WEST SUSSEX COUNTY COUNCIL CONSULTATION

TO:	Arun District Council FAO: Amber Willard
FROM:	WSSC – Highway Authority
DATE:	18 March 2026
LOCATION:	Land East Of The Croft Surgery Barnham Road Eastergate PO20 3RP
SUBJECT:	BN/10/26/PL Approval of details reserved by condition under BN/38/24/PL relating to conditions 5, 7, 16, 19, 20, 21, 22, 23 & 24. (See Application BN/12/26/DOC for conditions 8 & 9 - drainage). Additional plans received.
DATE OF SITE VISIT:	n/a (desktop study undertaken for purposes of this planning application)
RECOMMENDATION:	Advice

This is the **second** WSSC Highways response to the above planning application seeking approval of details reserved by condition under BN/38/24/PL relating to conditions 5, 7, 16, 19, 20, 21, 22, 23 & 24.

Comments below specifically respond to highways-related condition 16 (secure and covered cycle parking).

Description:
EXTERNAL WORKS Sht7

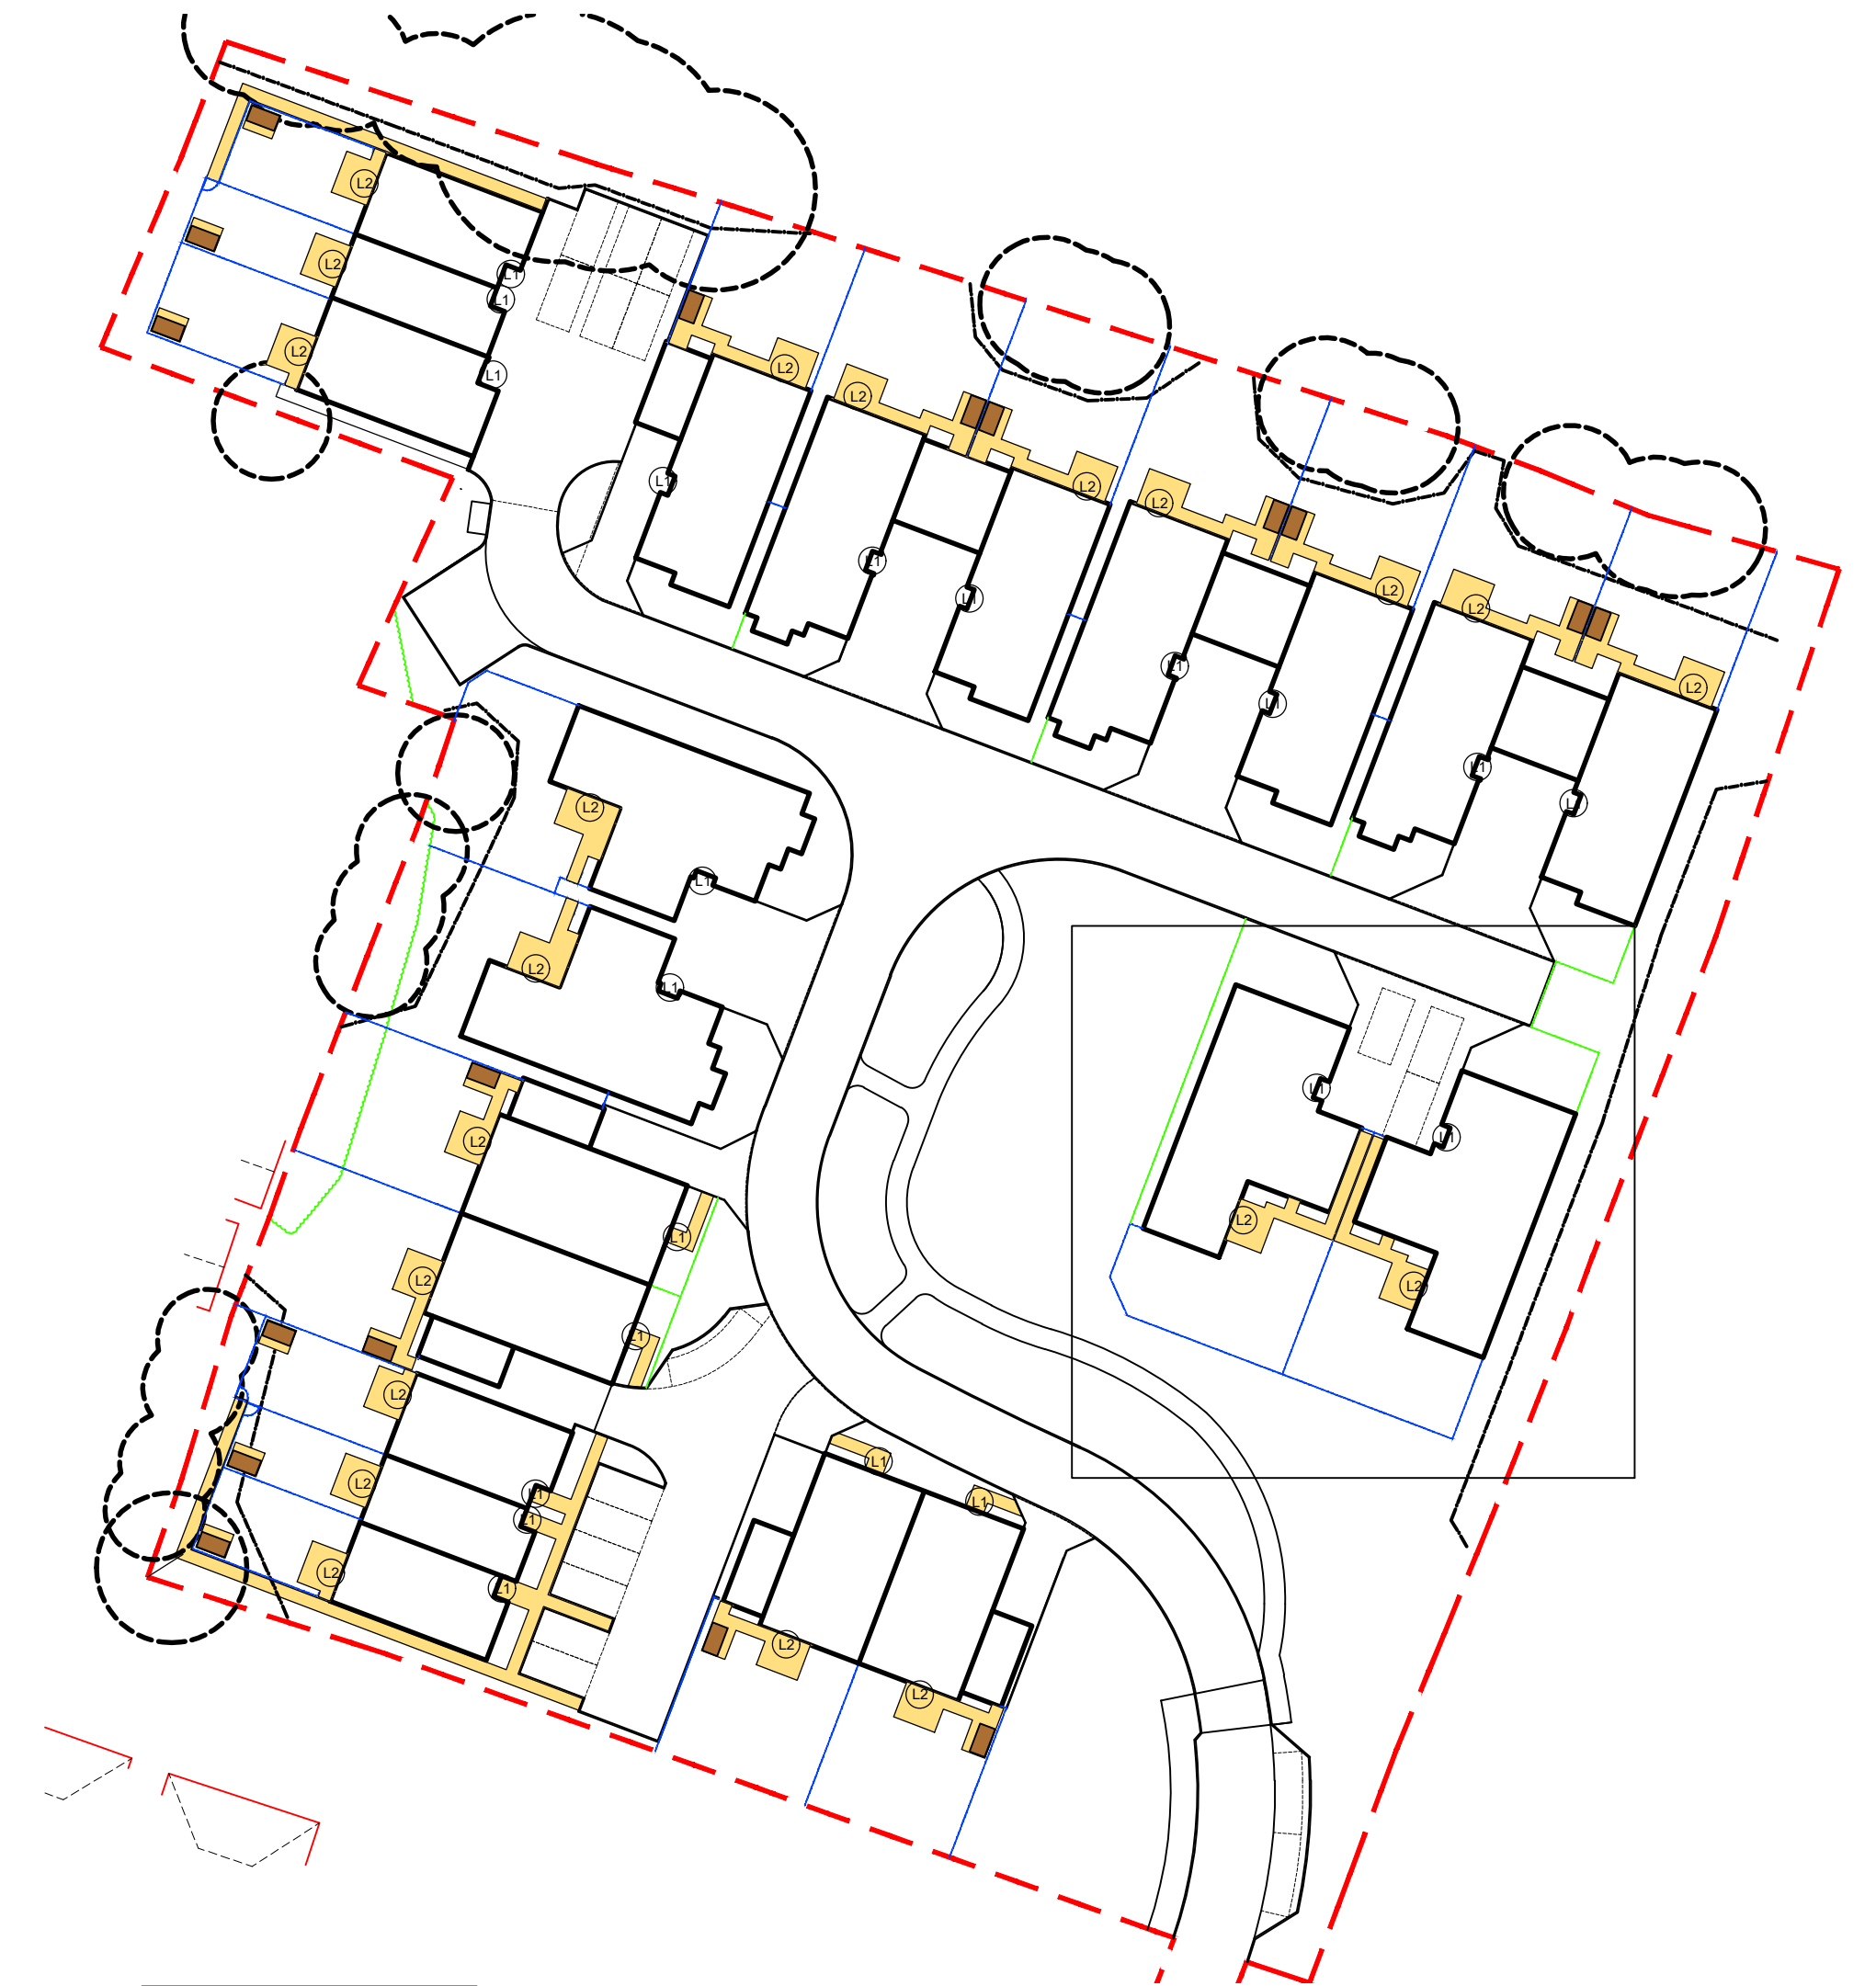
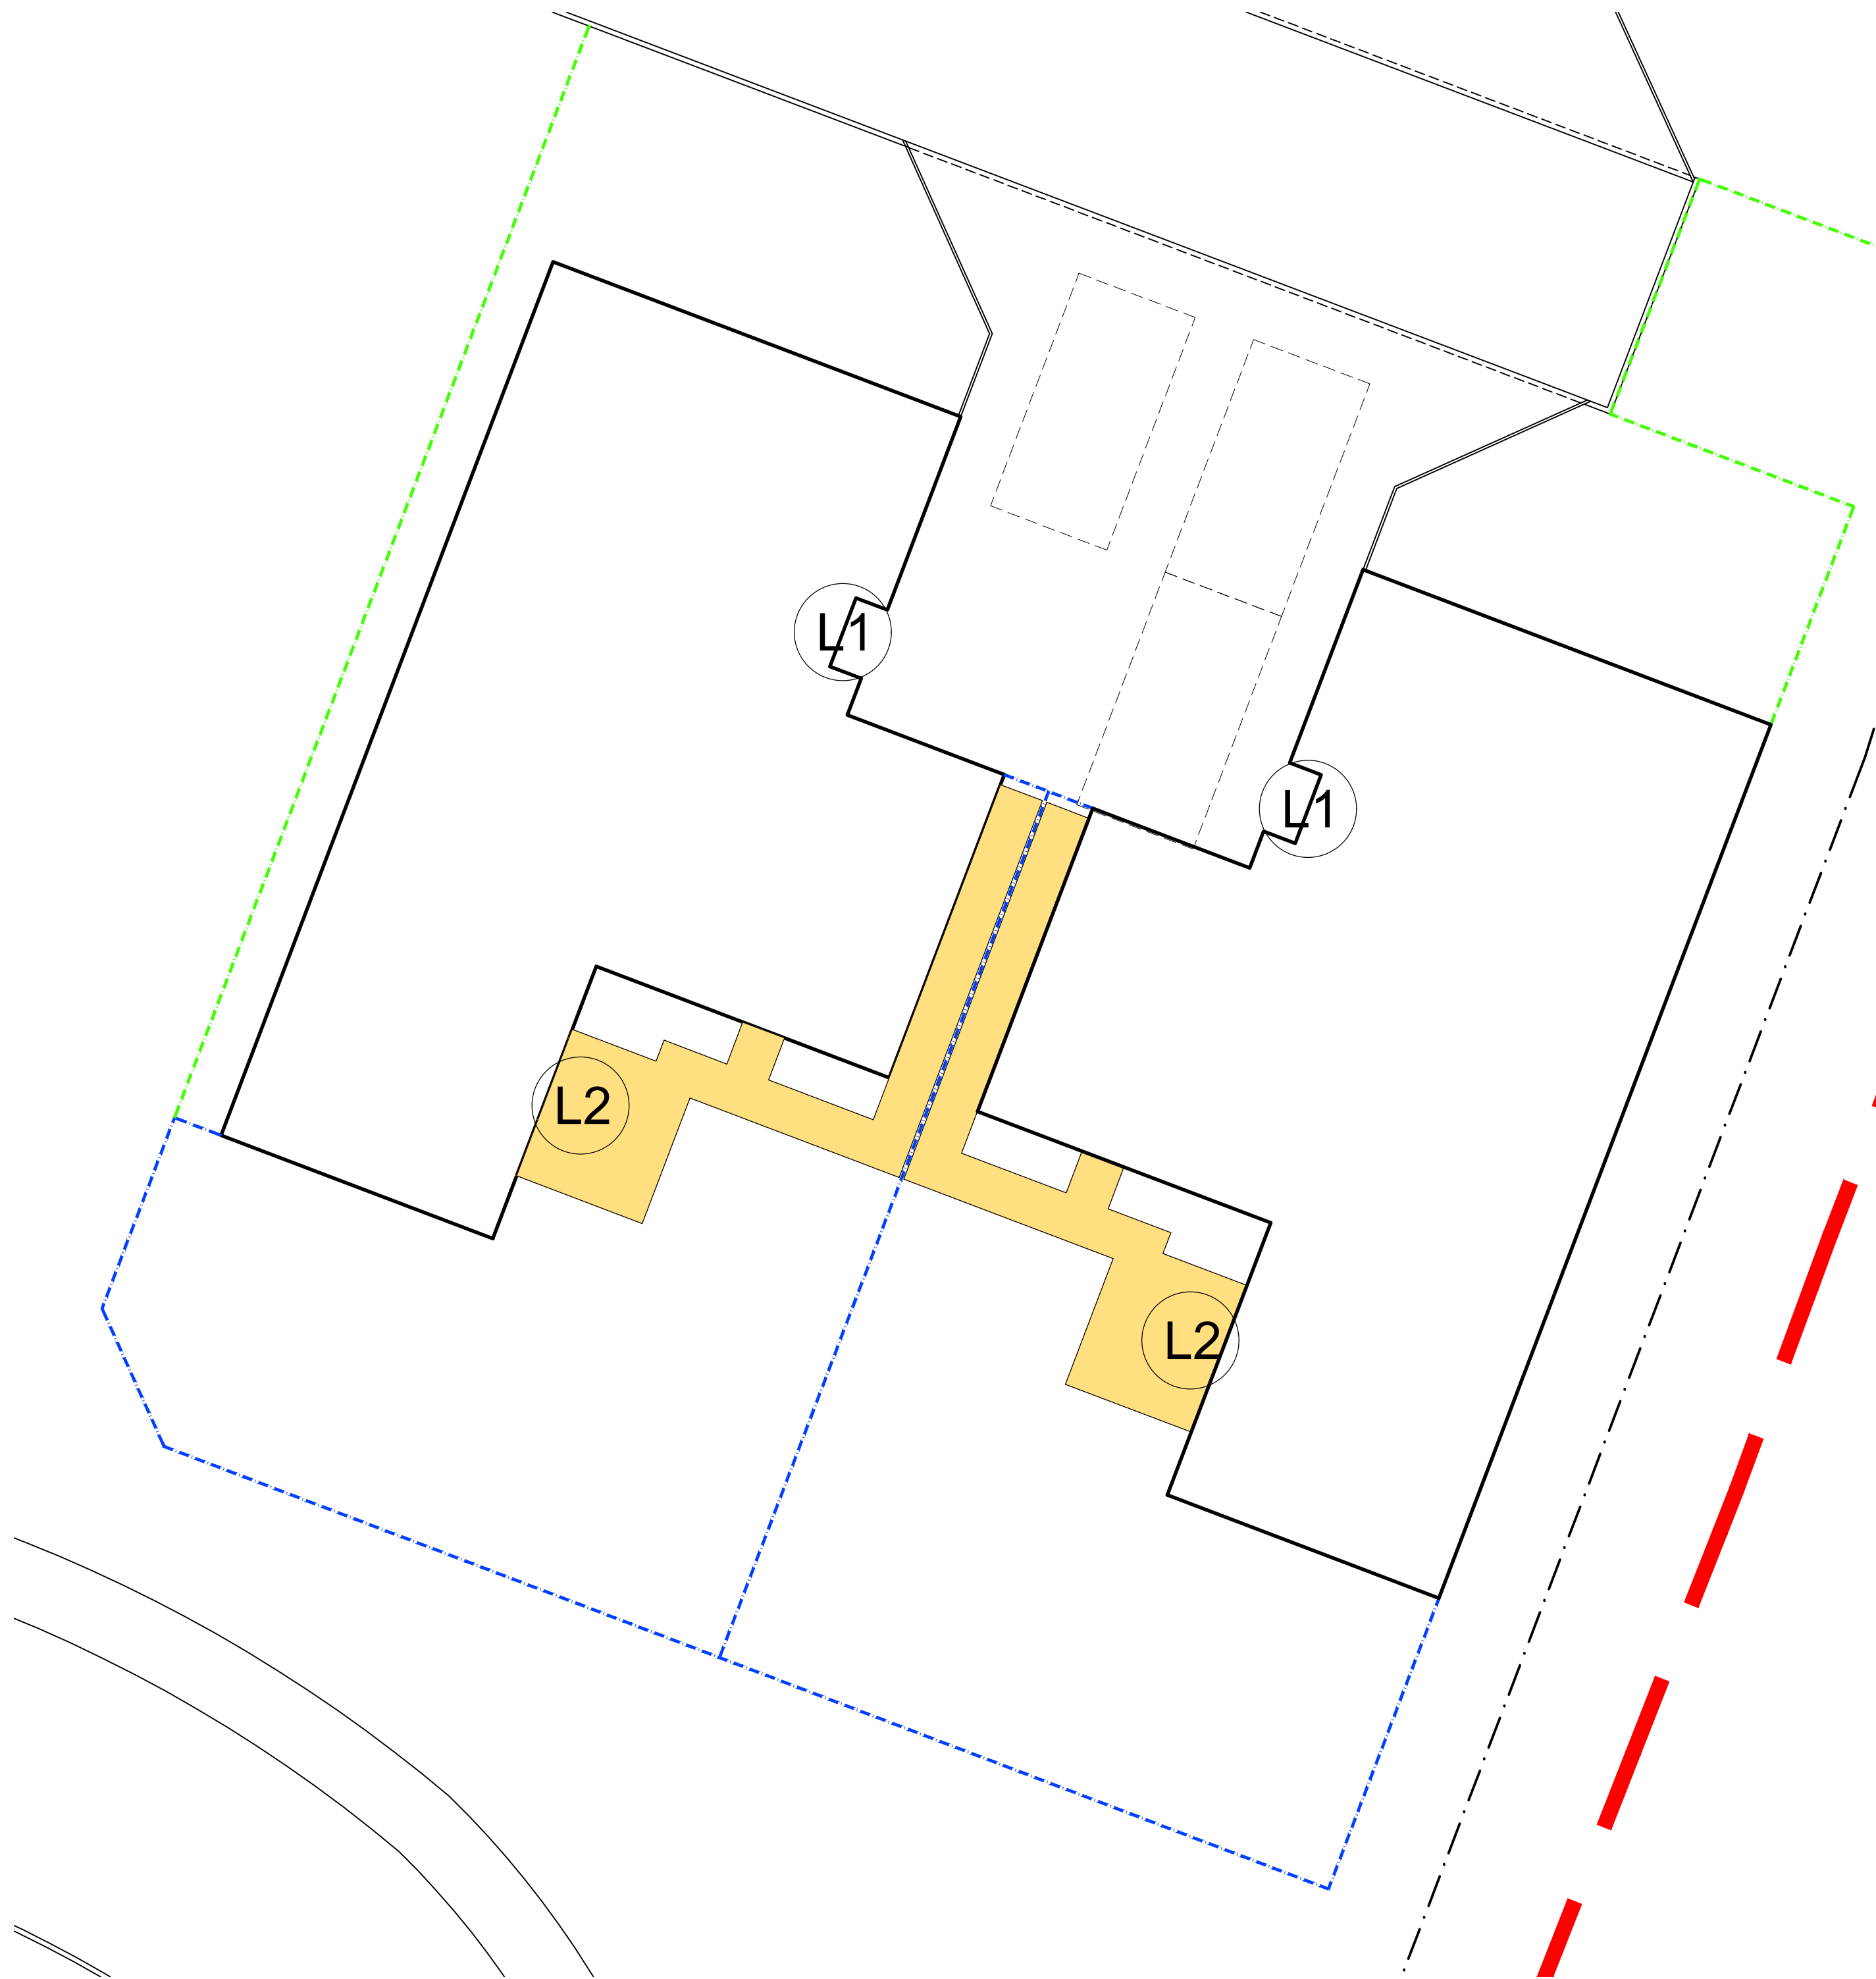
- (1)** The following extracts, taken from the external works plans, show the plots where it is not clear how access to the bicycle storage will be achieved from the access road. Applicant to provide details, please.

(2) And for the following (overleaf), no cycle storage is shown. Applicant to amend, please.

Drawing Number 2645-TFC-XX-00-DR-L-1001, revision P02, produced by Terrafirma Landscape Architects, now shows how cycle storage for each dwelling will be accessed.

This is also now shown (within garages) on Drawing Number 2645-TFC-XX-00-DR-L-1001, revision P02, produced by Terrafirma Landscape Architects.
